1000, LLC
CBP LOT 12-2
7190 COLE VIEW
COLORADO SPRINGS, CO 80915
EL PASO COUNTY, COLORADO

COUNTY FILE NO. PPR-16-027

Markup Summary

1 NORTH-WEST ELEVATION
SCALE: 1/4"=1'-0"

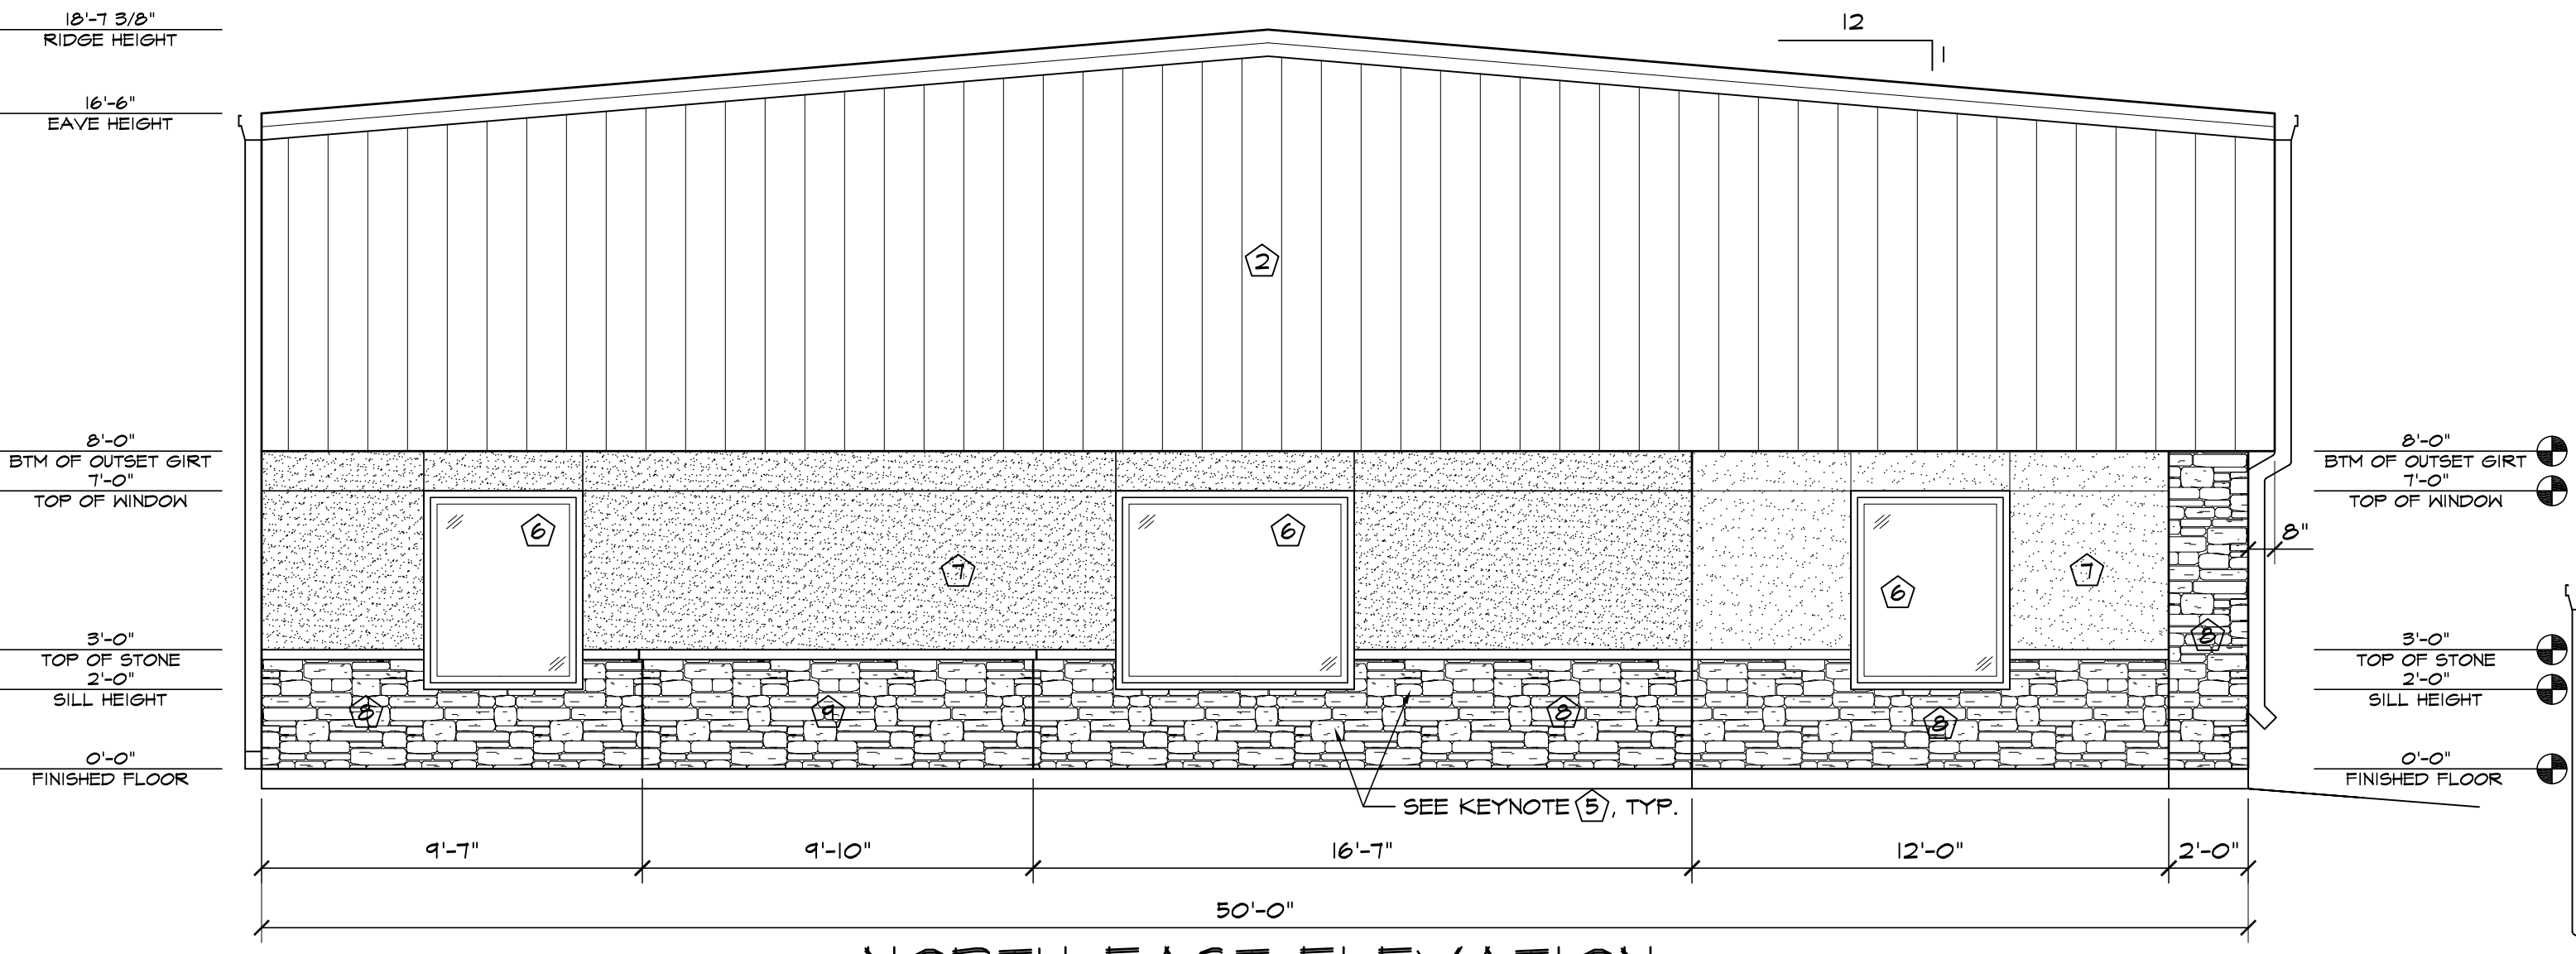
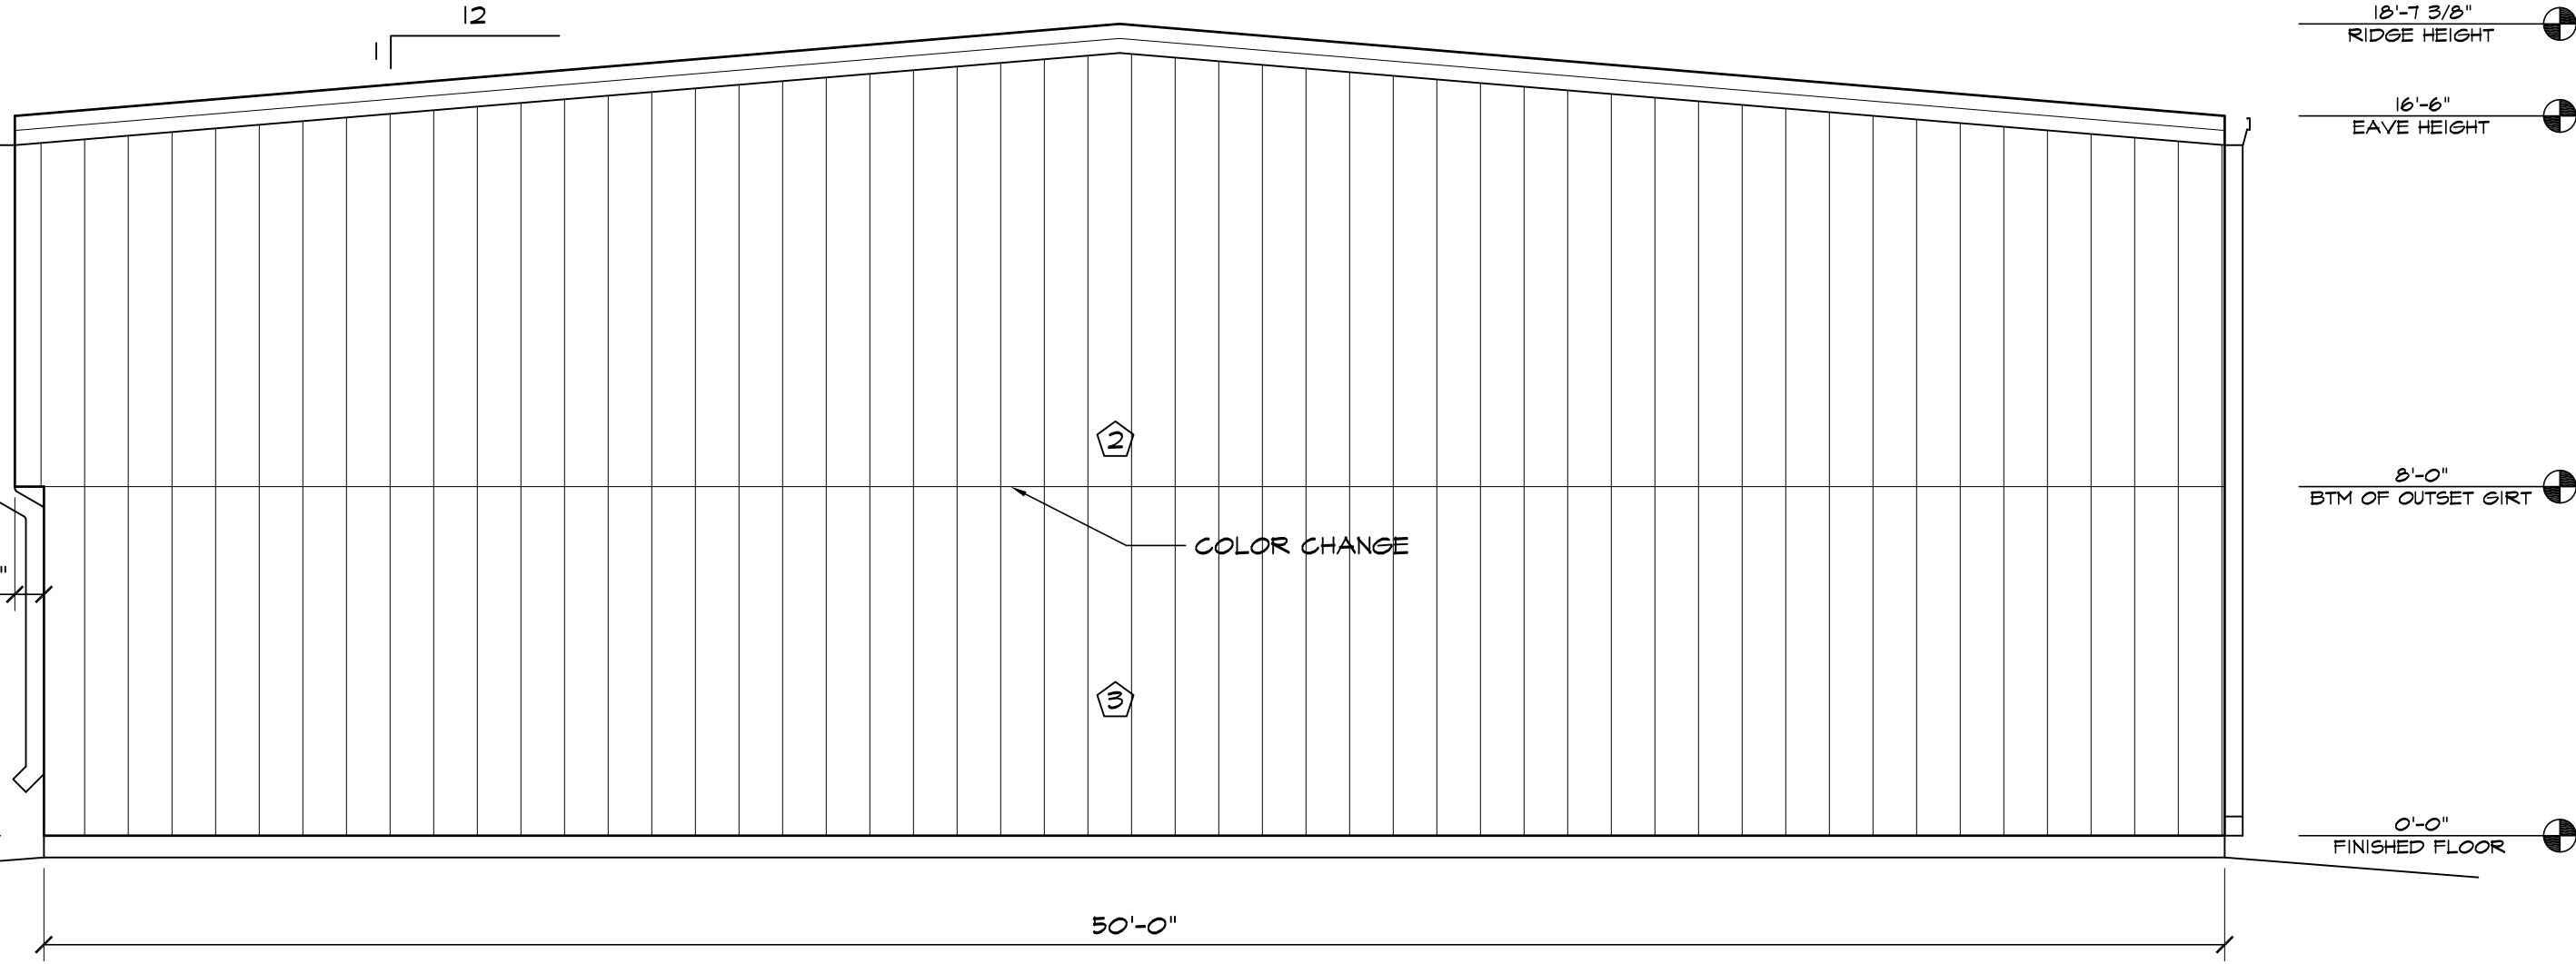
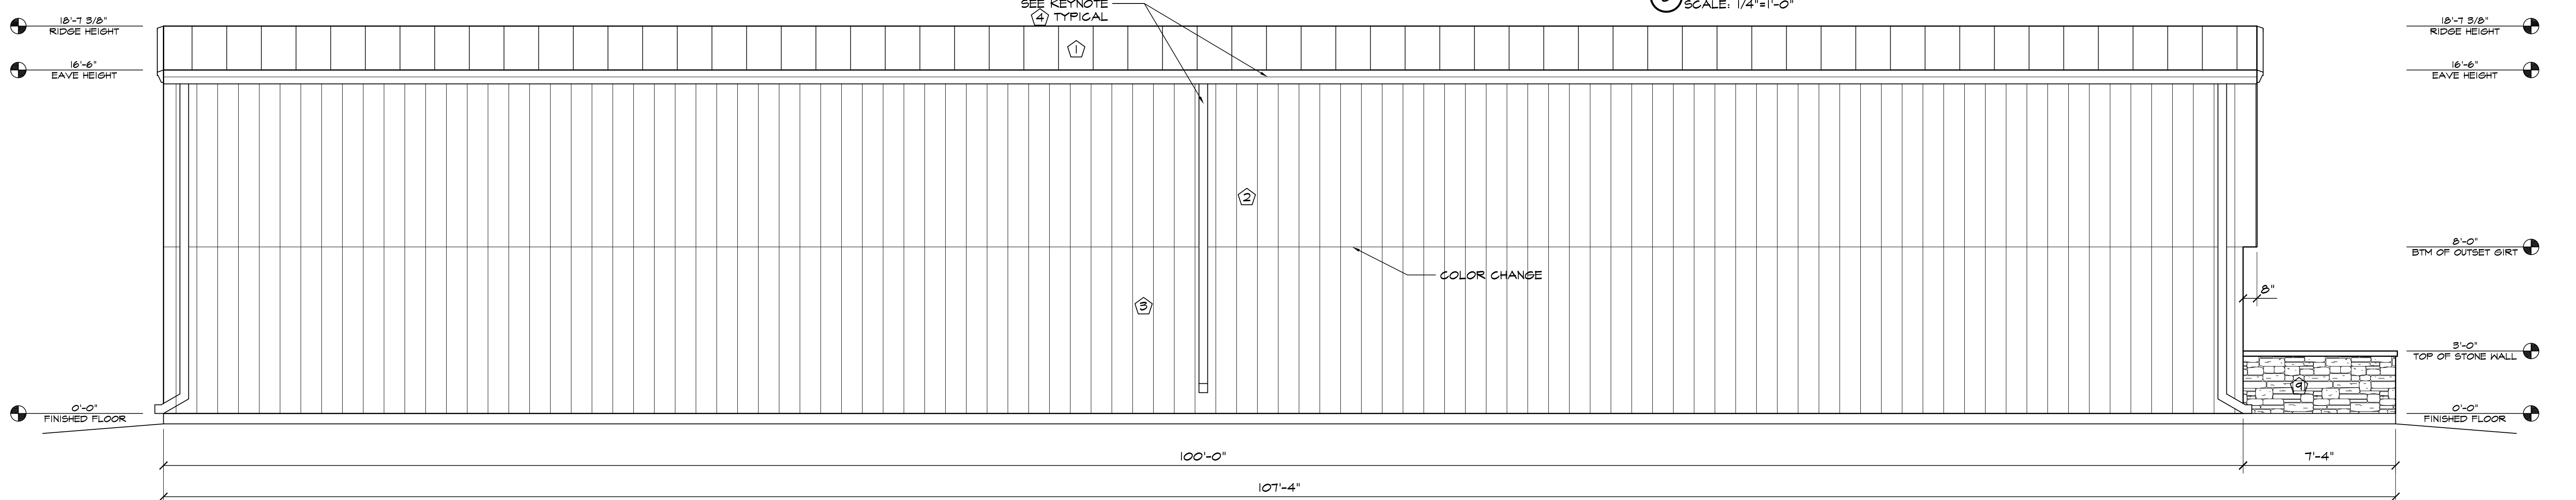
North-West per plans.

North-East per plans.

South-West per plans.

South-East per plans.

Direct downspout to drain into the proposed VQ facility.

Direct downspout to drain into the proposed WQ facility.

North-West per plans.

North-East per plans.

South-West per plans.

South-East per plans.
